**Consultation Response from KC,
Trees**

2026/91151 Fourways, Wolfstones Road, Upperthong, Holmfirth, HD9 3UU

Partial demolition of existing dwelling and erection of extensions and alterations, application of render, installation of package treatment plant and associated works

Proposed Site Plan 1:200

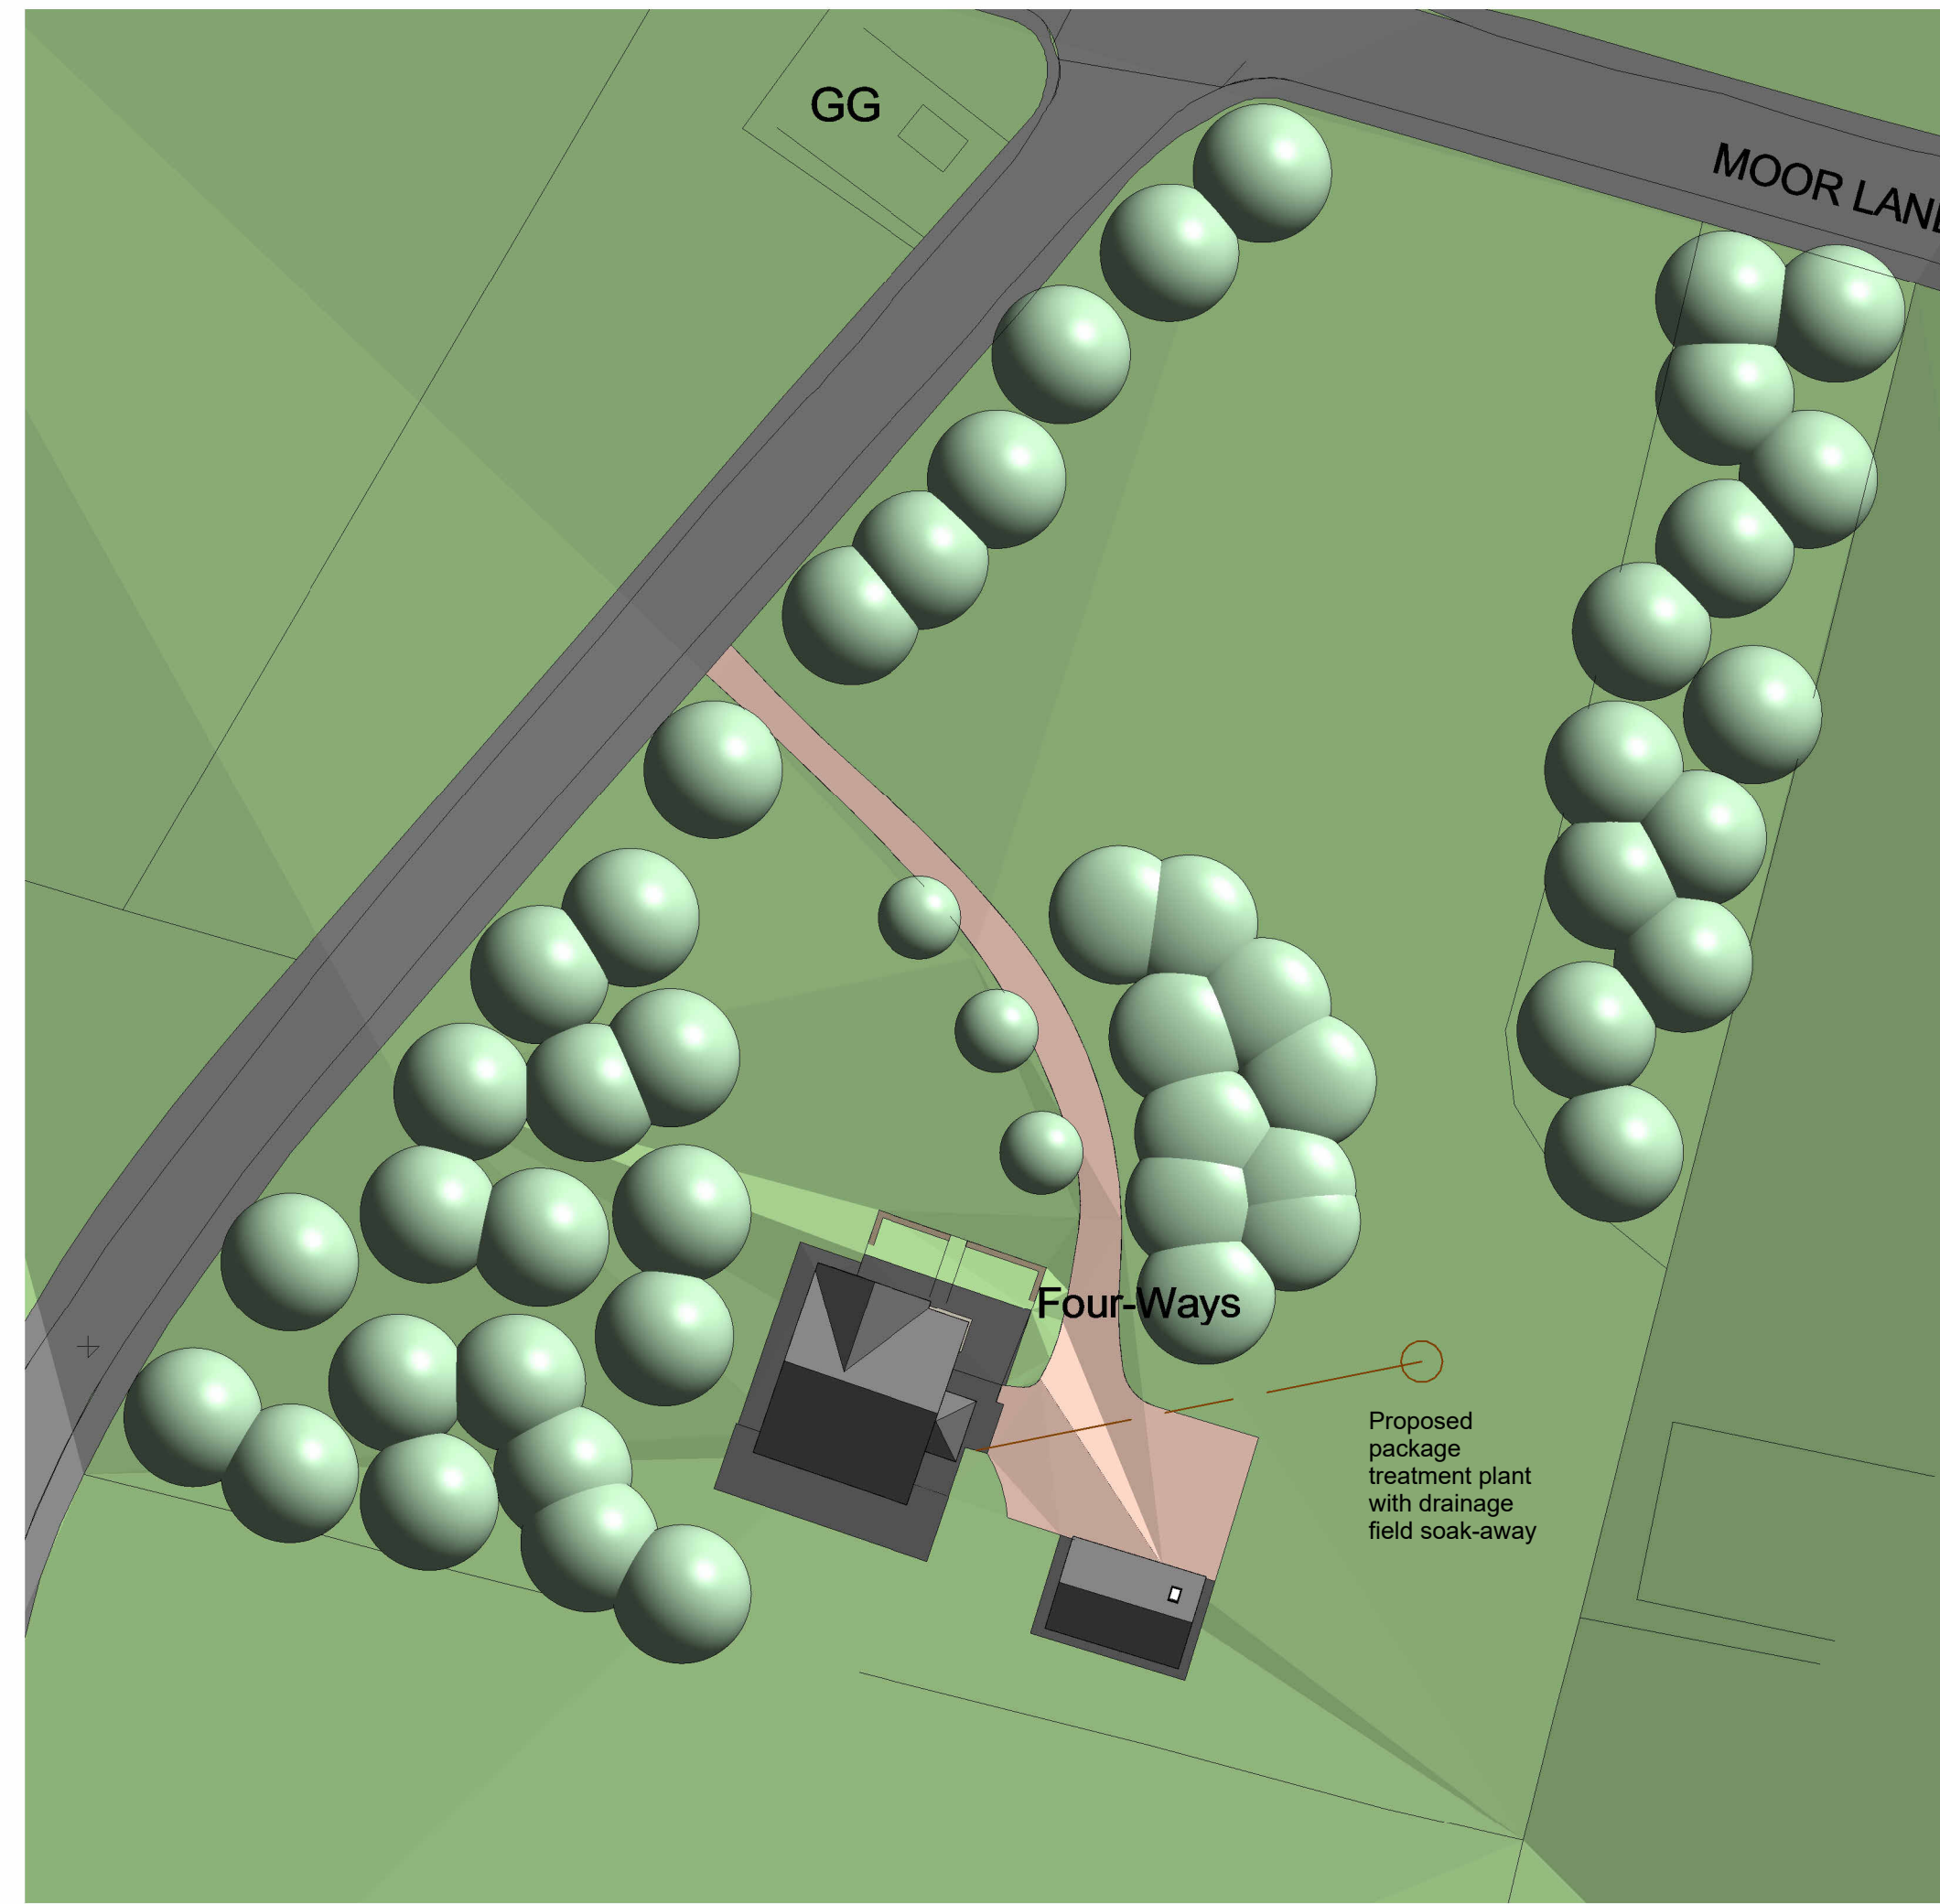
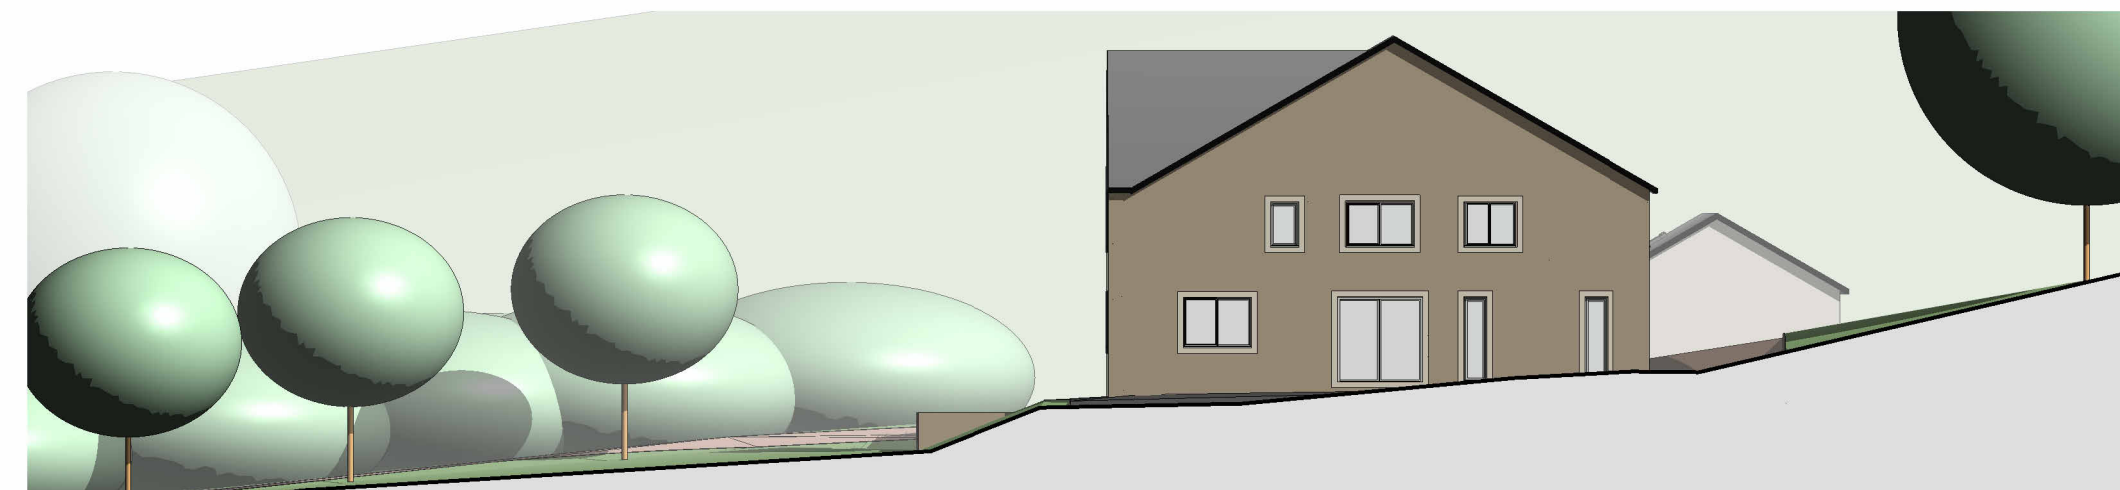
The proposed development looks achievable with the retention of all existing trees due to it being located on the existing footprint/hardstanding with a slight ingress towards the small woodland to the west.

Care should be taken to keep foundations outside of the neighbouring woods Root Protection Area with minimal root pruning being acceptable to roots under 25mm in diameter if they are encountered.
